Medworth Energy from Waste Combined Heat and Power Facility

PINS ref. EN010110
Document Reference: Vol 9.20
Revision: 3.0
Deadline 3
April 2023

Schedule of Changes (Deadline 3)

**Figure 10.1iii**  
**New Bridge Lane access proposal**

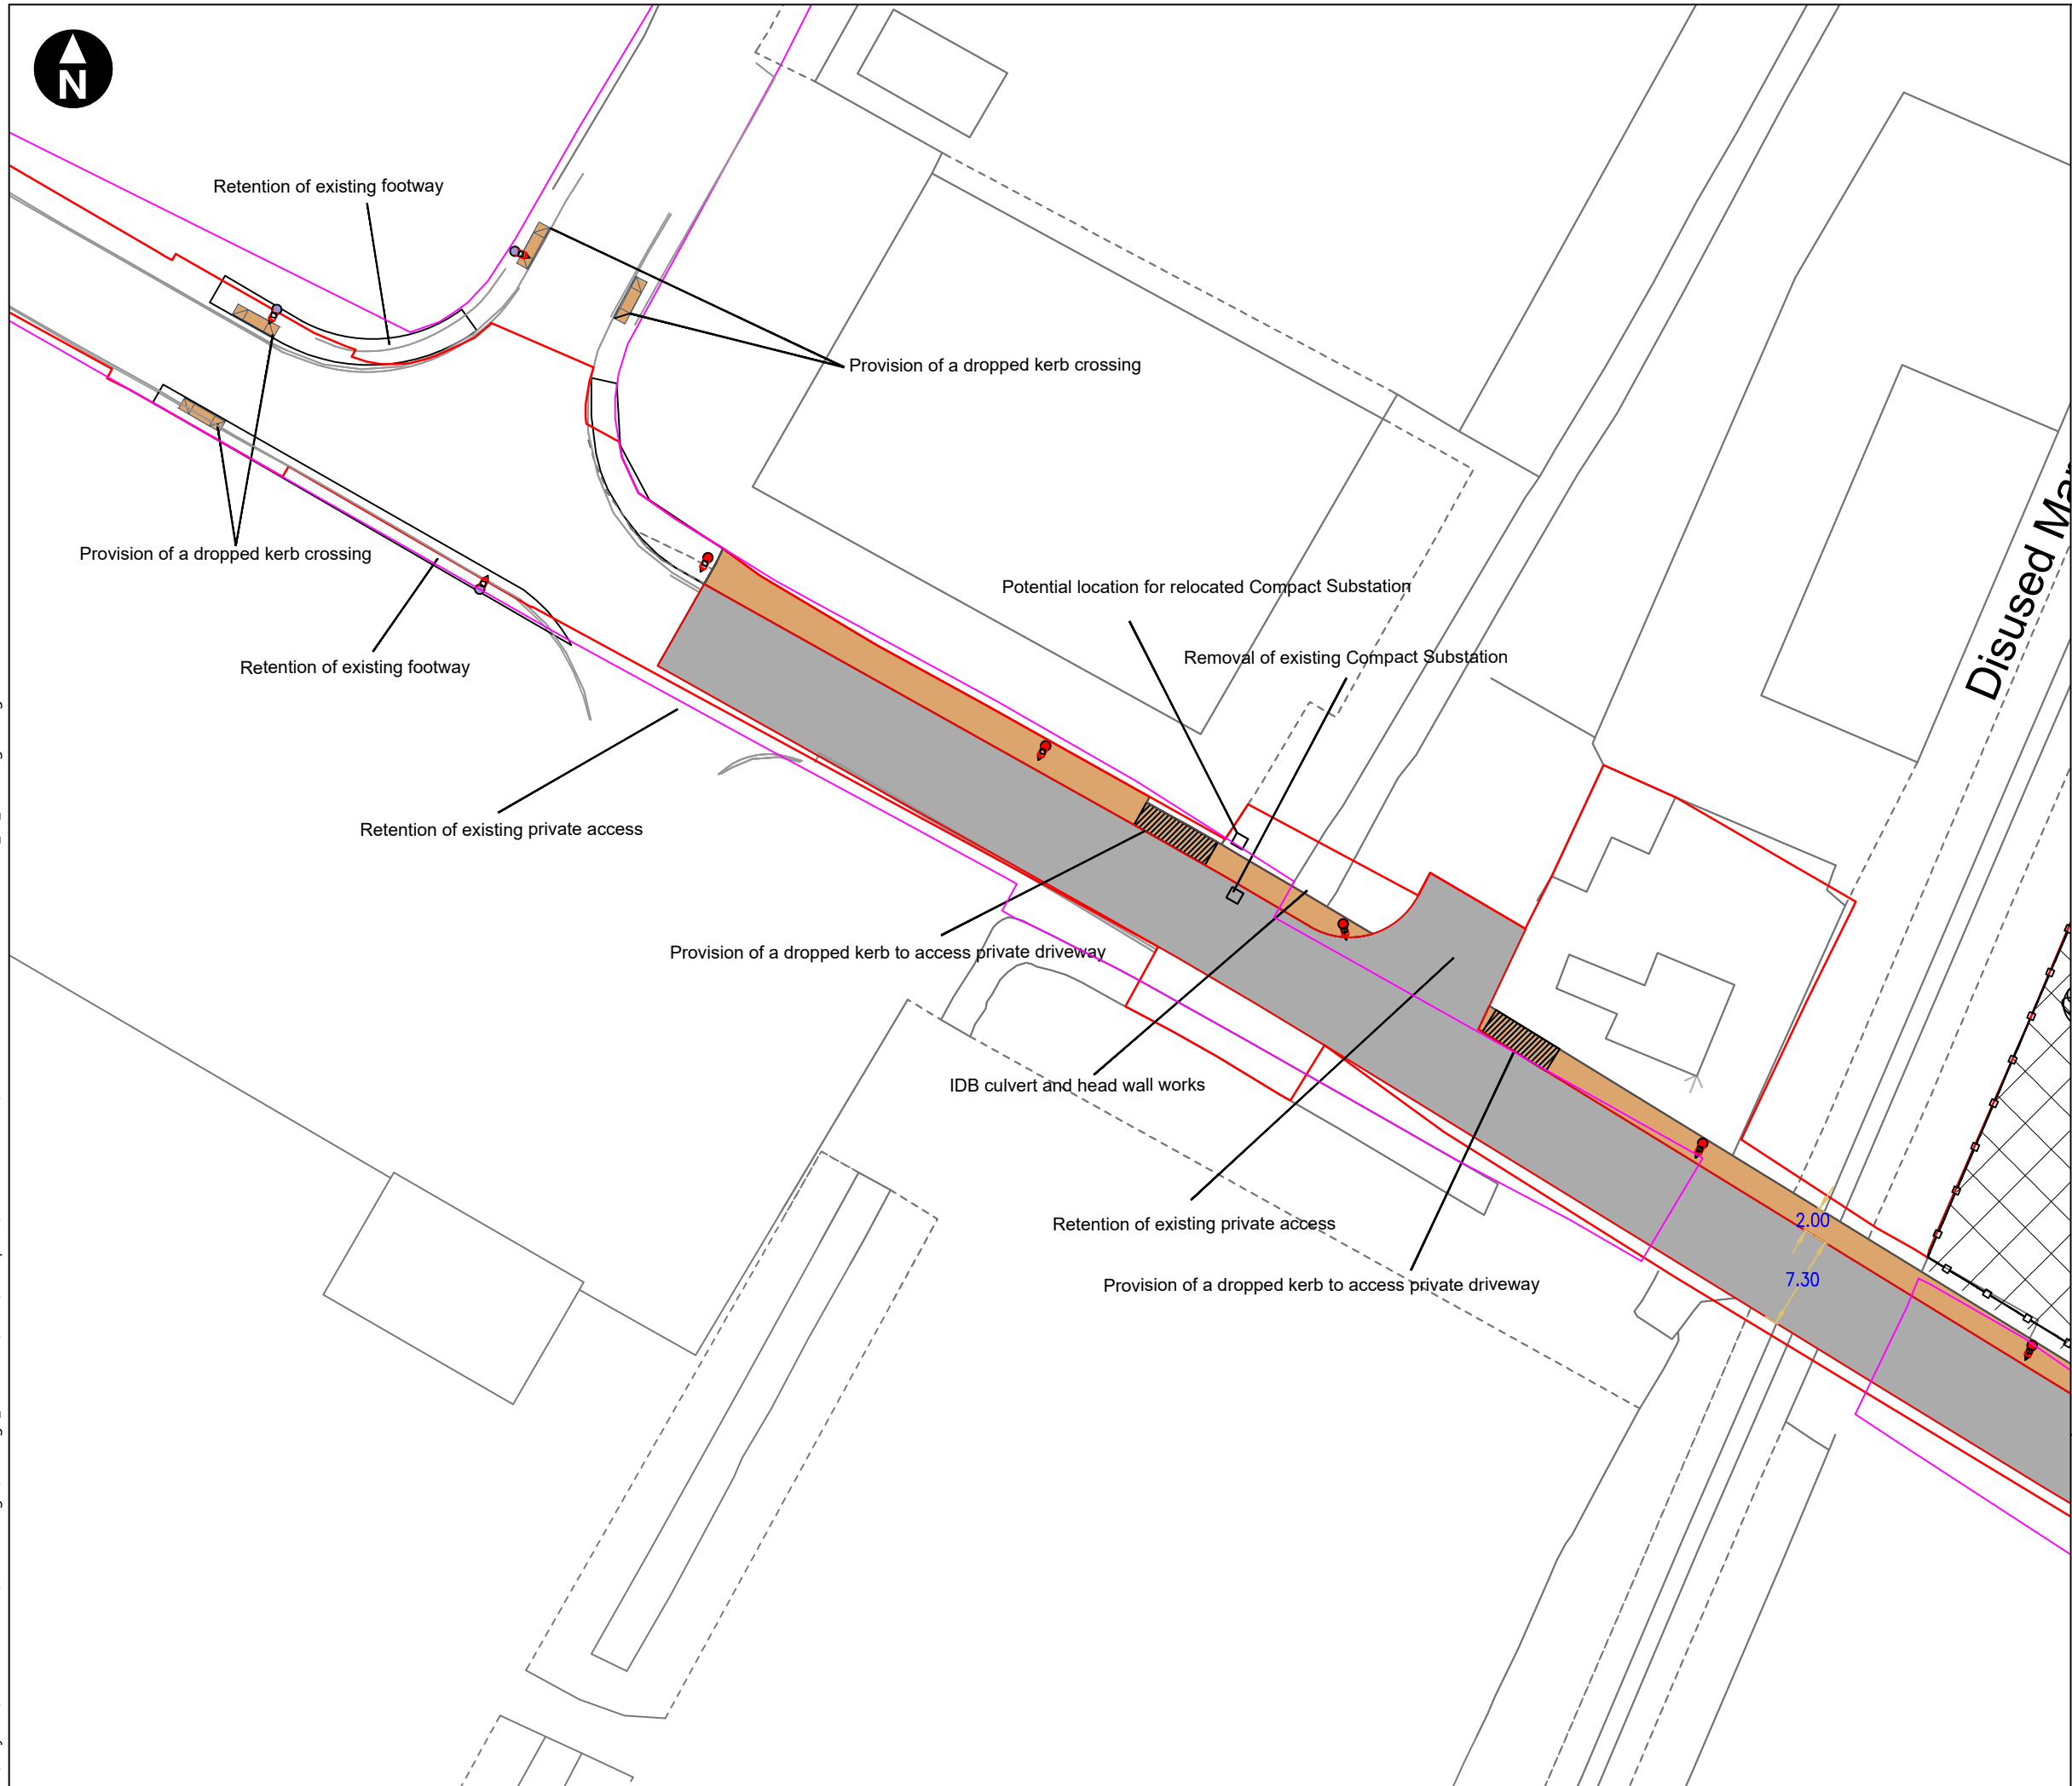
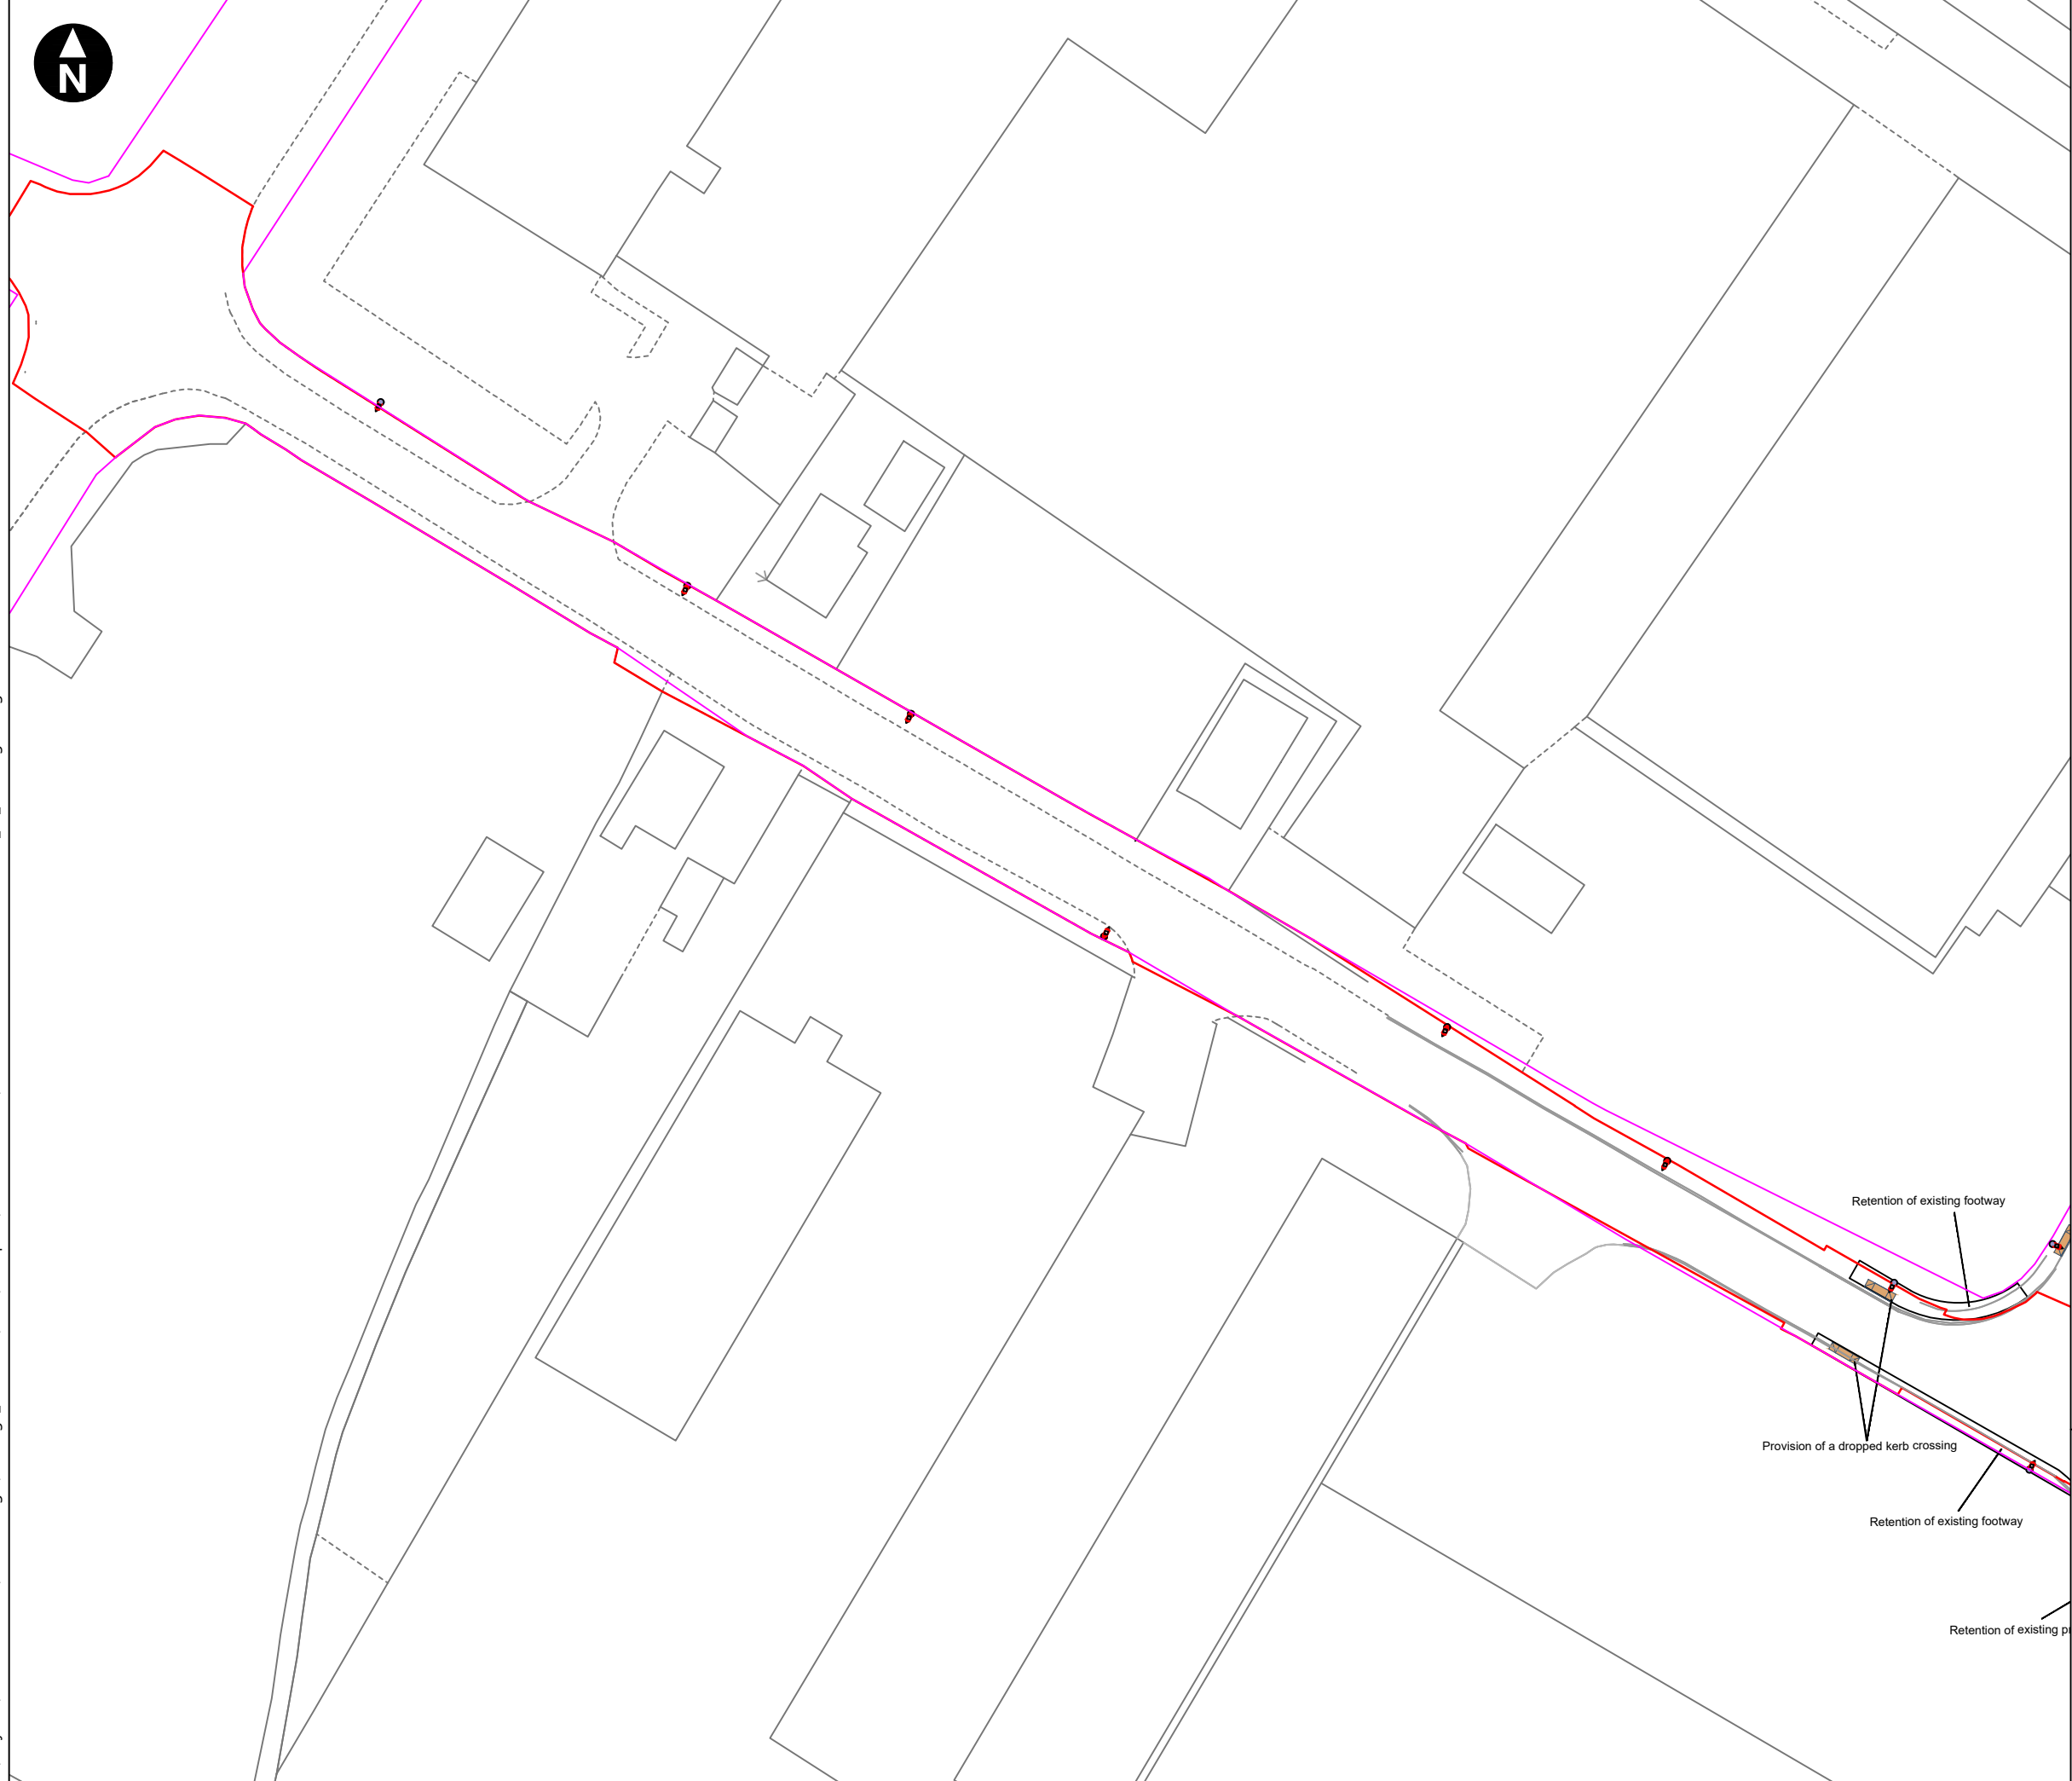
Document Updated	Change	Reason for change	Deadline submitted	Relevant Document version
Volume 6.4 ES Chapter 6 Traffic and Transport Appendix 6A Outline (CTMP) [REP1-011]	Paragraph 7.4.8 – additional paragraph to confirm that the Applicant, with the agreement of Network Rail, will retain/reposition/provide a sign setting out the rights of access applicable to NMUs at the point that New Bridge Lane crosses the Disused March to Wisbech Railway.	CCC and FDC LIR paragraph 2.4.3 [REP1-074] .	Deadline 3	Rev 3
Volume 6.4 ES Chapter 6 Traffic and Transport Appendix 6A Outline (CTMP) [REP1-011]	Additional drawings, Figures 9.2ii to show swept path of vehicle leaving New Bridge Lane. Also Figure 10.3i – ii to show outline design for construction accesses into the CHP Connection Corridor from Weasenham Lane and accompanying swept path.	CCC and FDC LIR paragraph 2.7.32 and 2.7.34 [REP1-074] .	Deadline 3	Rev 3
